Application no: 23/02713/DISC

Location: OS Parcel 6372 South East Of Milestone Farm, Broughton Road, Banbury

Lead Local Flood Authority

Document reviewed: Balmoral Avenue, Banbury (Phase 2) SUDS Management Strategy September 2023 REPORT REF: 27526-CIVL-0202

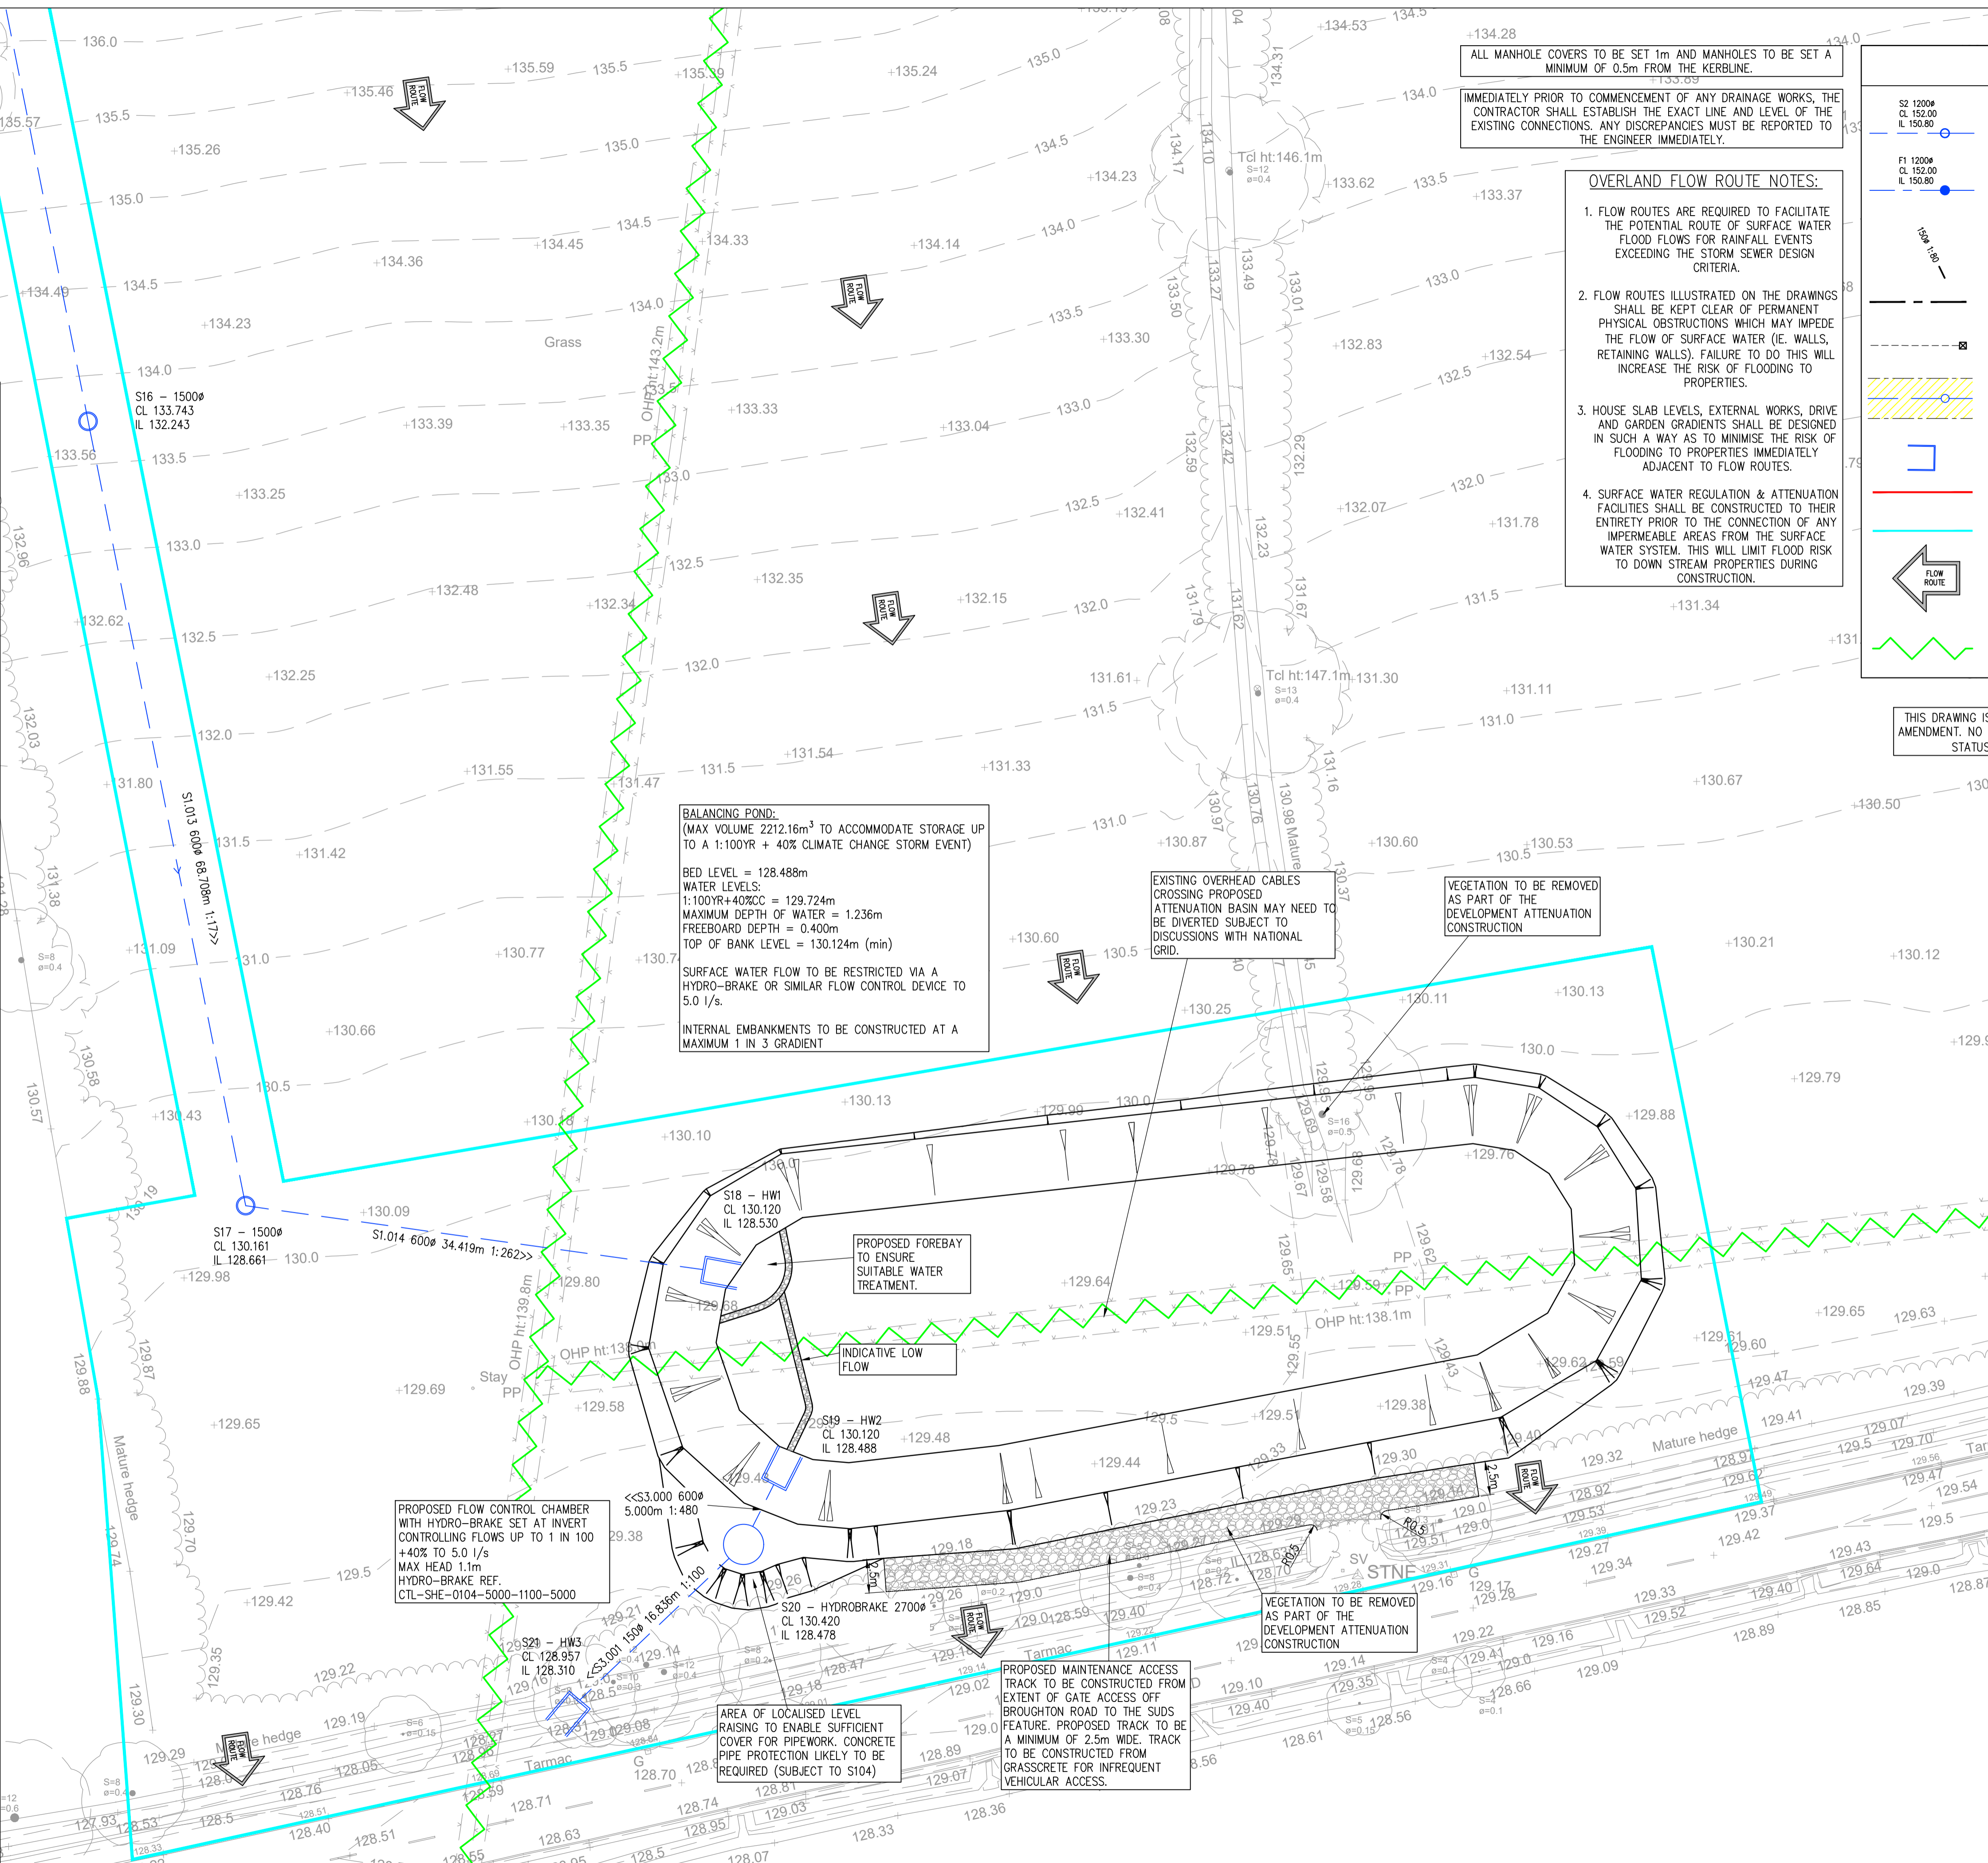
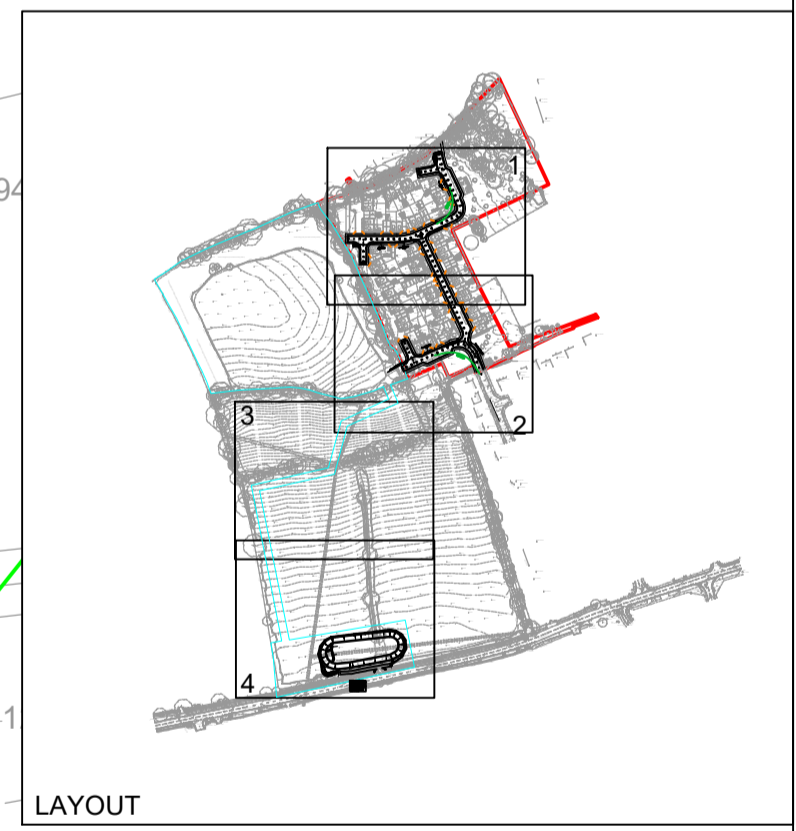
The inlet and outlet pipes are in close proximity. The forebay area should be increased in proportion to the size of the proposed pond.
